PLANNING - LEVEL III REVIEW (14-526): MMC Congress Street Medical Building (285KSF) (19 procedure rooms, 64 patient rooms, licensed bed count remains 637)
Institutional Overlay Zone

IOZ - ZONING ANALYSIS

Preliminary Review (10/10/18)	
Transportation	a. Impact on Surrounding Street Systems	Traffic Movement Permit analysis to come pending scoping meeting

1/16" = 1'-0"

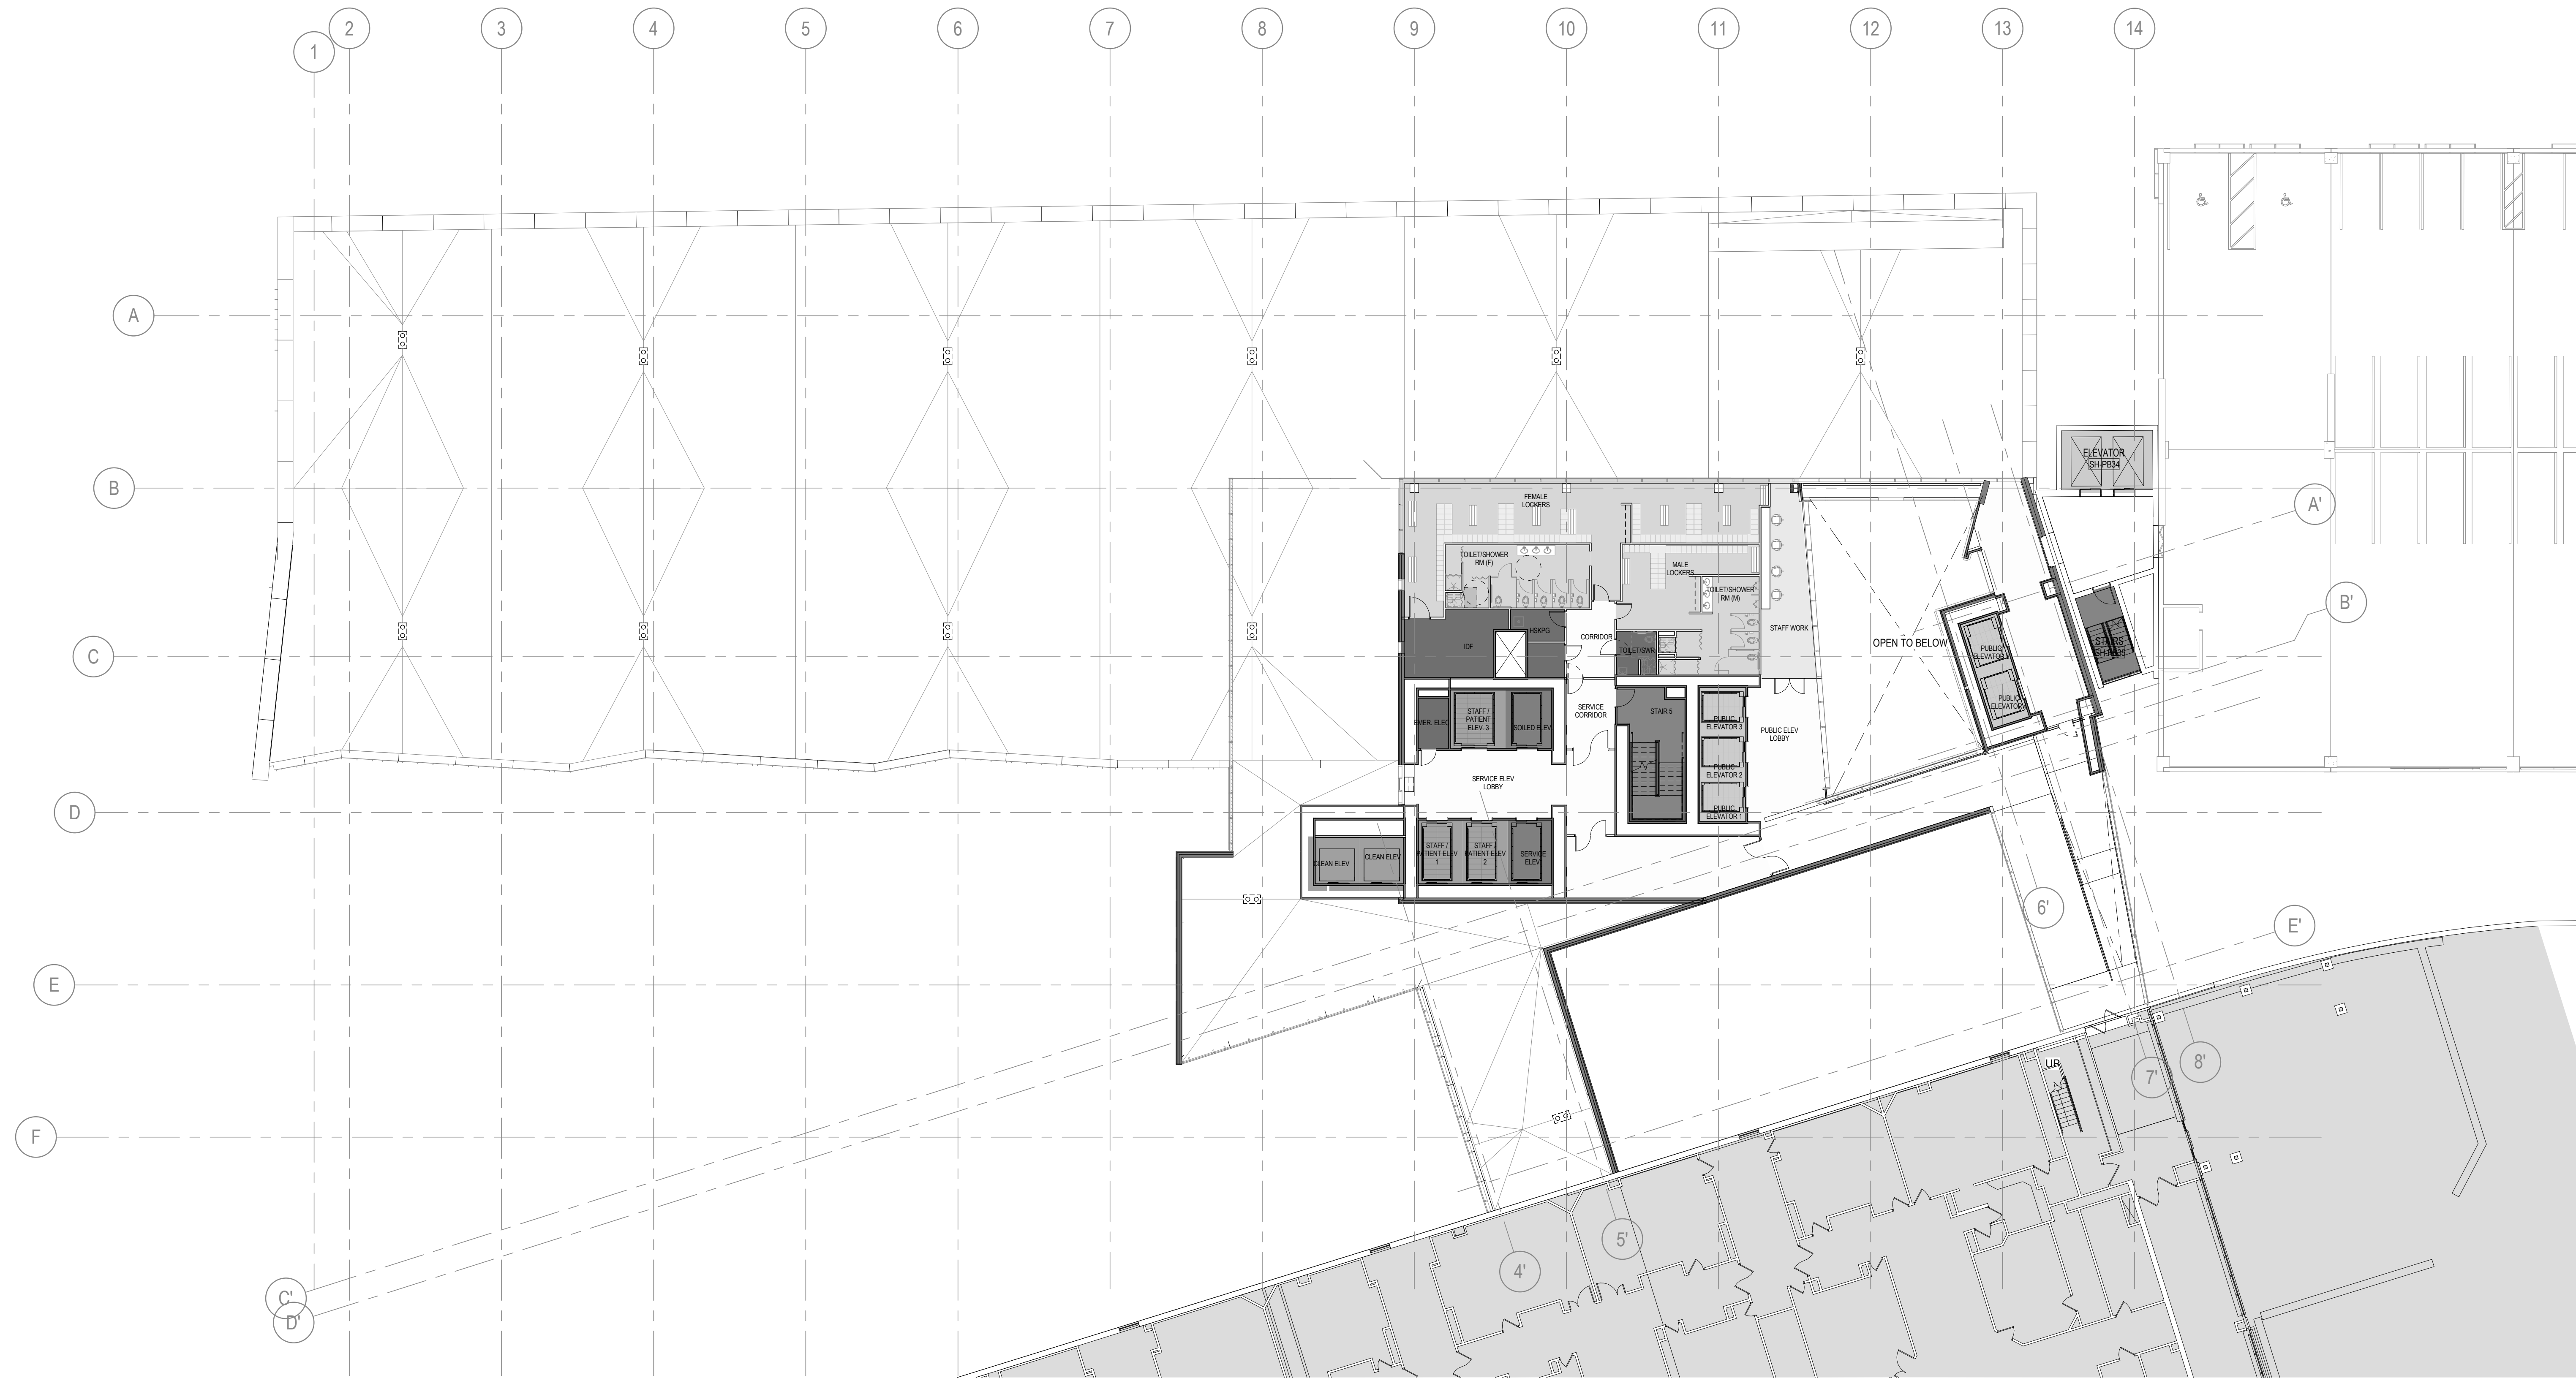
- a. *Use*
- b. *Dimensional Requirements*
Provide analysis with respect to dimensional requirements in the revised submittal.
- c. *Design*
See comments by others.
Please provide floor plans in revised submittal
- d. *Signs*
See below.
- e. *Transportation*
- f. *Environment*
- g. *Mitigation Measures*
- h. *Neighborhood Integration & Neighborhood Engagement*
- i. *Construction Management*
See comments by others.
Please provide some discussion on attempts to minimize impacts to pedestrian circulation along the south side of Congress Street. Could sidewalk closure be limited to certain construction/demolition phases?
Provide discussion on bike accessibility around the construction site.
- j. *Other*
